Comments for Planning Application 23/02604/HOUSE

Application Number: 23/02604/HOUSE

Address: 7 Valle Gardens Leigh Kent TN11 9FA

Proposal: Double storey side extension consisting of an attached garage and 4 new rooms, replacing existing car port. New doors added to snug.

Site Address: 7 Valle Gardens, Leigh, Tonbridge, TN11 9FA
Date: 28/11/2023
Title: Site Plans
Drawing Number: EB0005aVG
Scale: 1:200 @ A3

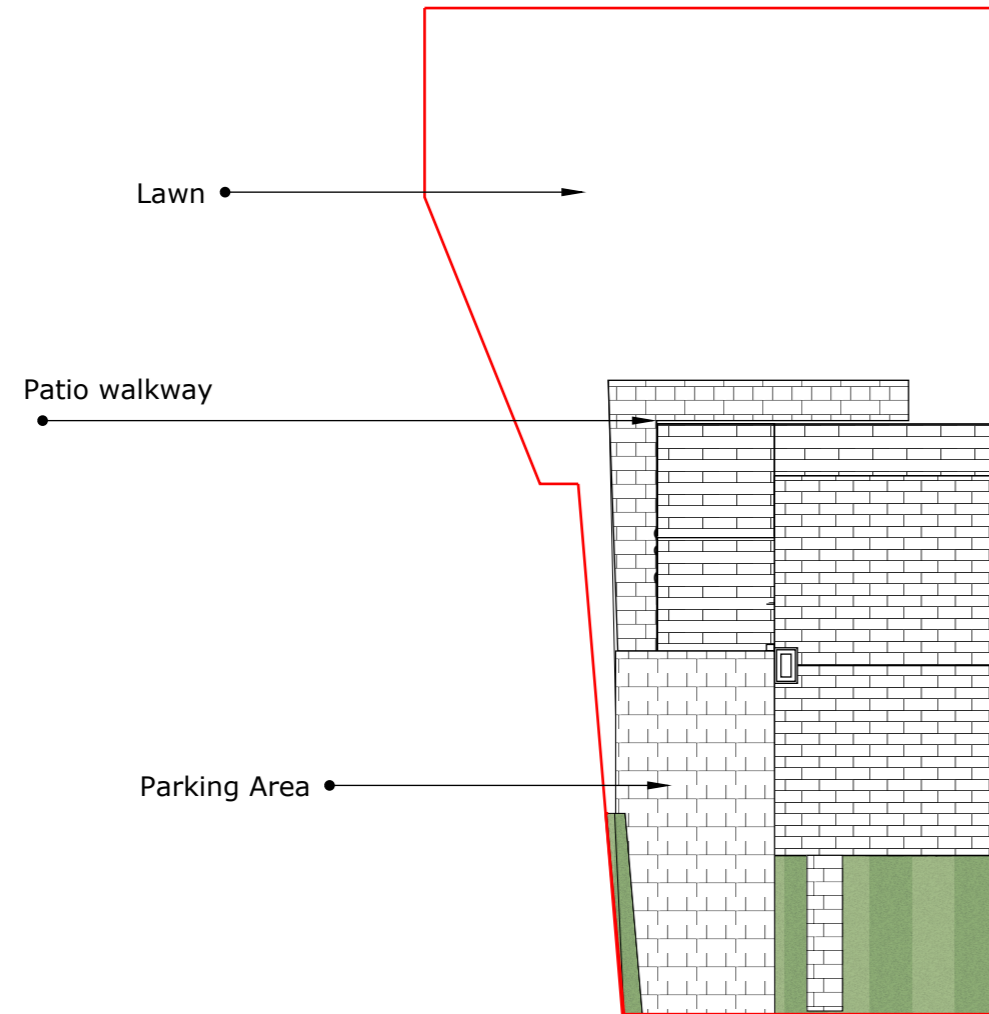
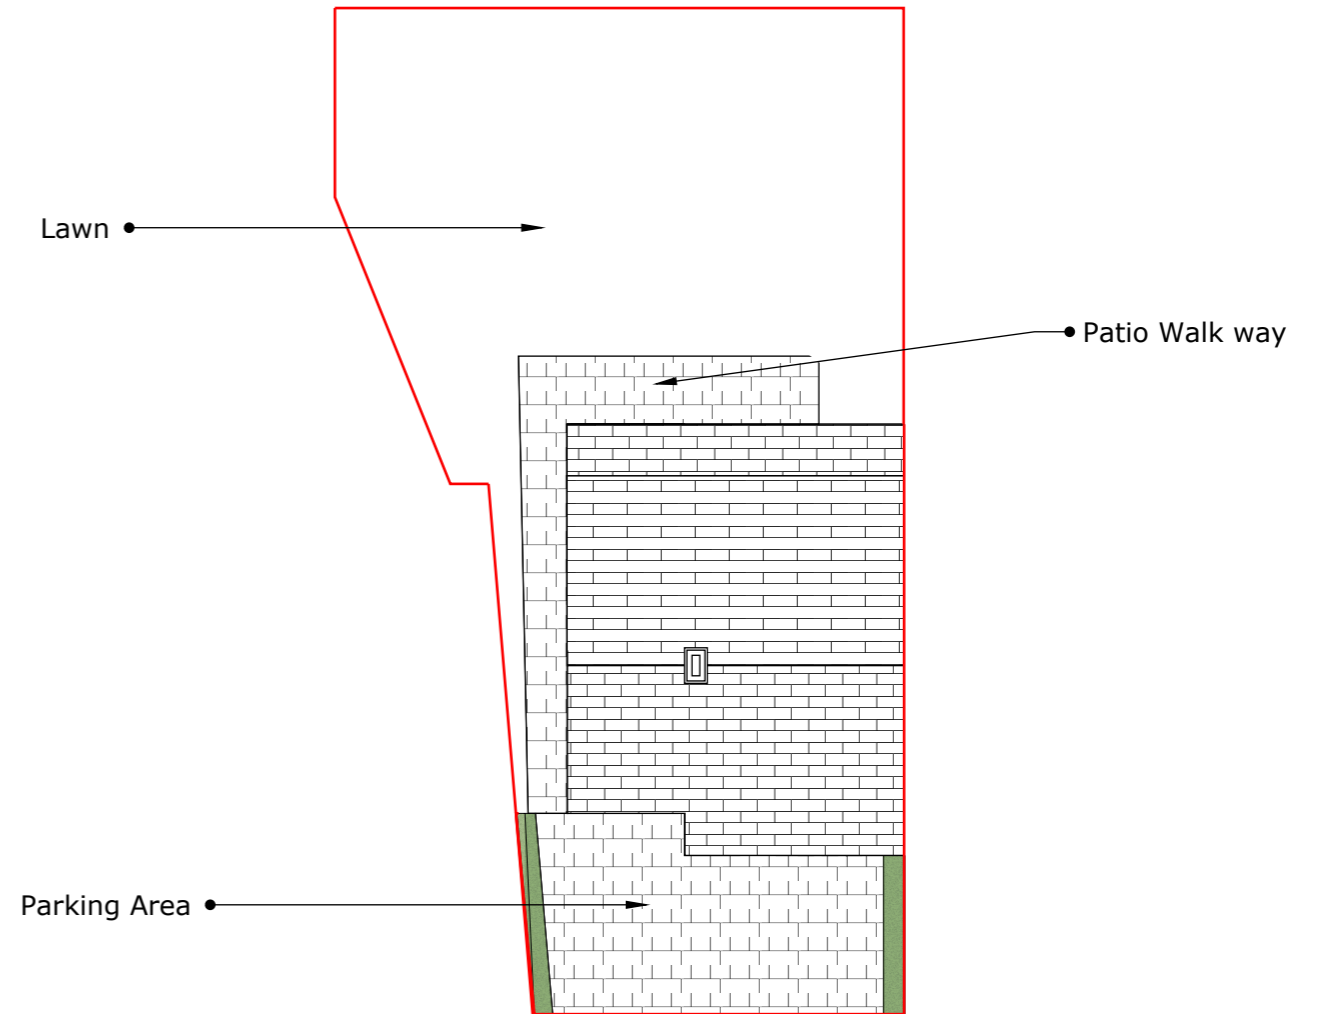
The proposed two-story extension aims to significantly expand the residential dwelling. The ground floor will feature a kitchen, W.C., lounge, and a snug, while the first floor will have five bedrooms, two bathrooms, and a shower room. The parking arrangement will undergo significant changes, including the removal of the car port to make way for the snug. Additionally, a garage will be built in place of one parking space, leaving one space available for parking.

The inadequate parking space would necessitate residents to use visitor parking bays directly opposite. It's important to note that it is against the properties' development covenants to leave residents' cars in visitor bays for more than 24 hours. If the residents plan to monopolize the visitor parking at the development, visitors will be forced to park along the road, which not only inconveniences them but also affects the overall accessibility and would pose difficulties for delivery drivers, postal services, and particularly the bin lorry on a regular basis. It would also create challenges for emergency services should the need arise when trying to access our property along Valle Gardens.

Another concern is that one of the new residents at the property requires the use of a disability vehicle that needs constant access to its rear. This is essential for the individual to get into the vehicle comfortably. This requirement clearly necessitates extra space to be provided for parking. If parked on the driveway after the extension, it would force the individual to access the vehicle
